## City of Albuquerque Stormwater Construction Site Inspection Report

General Information					
ESC File No.	M15E008	Project Name:	Wagoner Building		
NPDES Id. No.	NMR1005TB/NMR1005TC	Location:	1800 Randolph Rd SE		
1/10/2025	Owner	Contractor			
Operator	LOE Investments LLC		Eastley Inc.		
Contact name & title	Matt Wagoner		Matt Wagoner		
e-mail	<a href="mailto:matt@eastleyinc.com">matt@eastleyinc.com</a>		<a href="mailto:matt@eastleyinc.com">matt@eastleyinc.com</a>		
Contact Phone #	951-712-1394		951-712-1394		
COA Inspector	Chancellor English		Start/End Time:	12pm	
Construction Phase:	Foundations				
Type of Inspection:	Regular	Storm Event	Post Storm Event >0.25"	311/Complaint	Follow Up
Weather at time of inspection?	Clear		Temperature: ~	35	
Estimated date of last storm 0.25" or greater	11/7/2024

1 SITE GRADING AND DRAINAGE PLAN

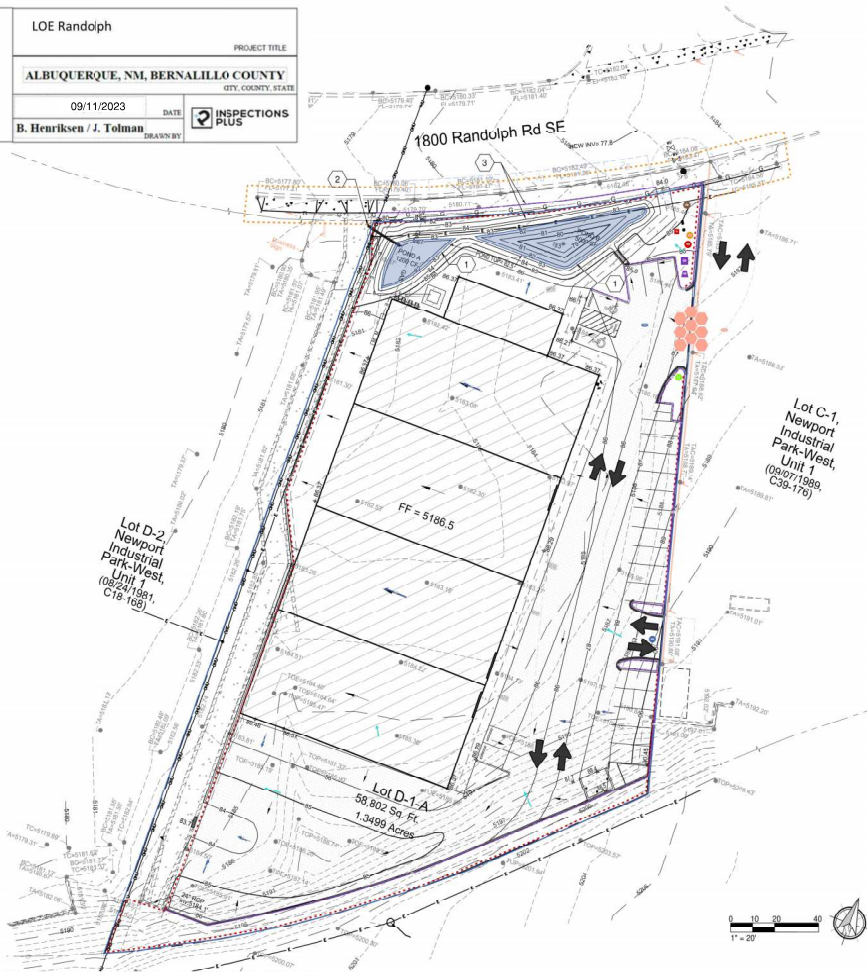
3	BMPs - There is a gap between the retaining wall and the perimeter silt fence on the northwest corner in violation of CGP Part 2.1.2. Sediment basins have not been installed in violation of CGP Part 2.1.3. Required mitigation: Design and install all stormwater controls in accordance with good engineering practices, including applicable design specifications per CGP Part 2.1.2. Complete installation of stormwater controls by the time each phase of construction activities begin per CGP Part 2.1.3.				
4	Waste - The waste bin was left uncovered in violation of CGP Part 2.3.3.e. Required mitigation: For construction and domestic wastes, provide waste containers of sufficient size and number to contain construction wastes and provide cover to minimize exposure of wastes to precipitation per CGP Part 2.3.3.e.

2.1	Discharge off site? (Y/N)	no			
4	Self Inspection Reports	No	Latest report Date:	N/A	
Notes:					
The waste bin and porta potty are stored on the neighboring parking lot and not shown on the ESC Plan which is a possible SWPPP violation for having an out-of-date map.
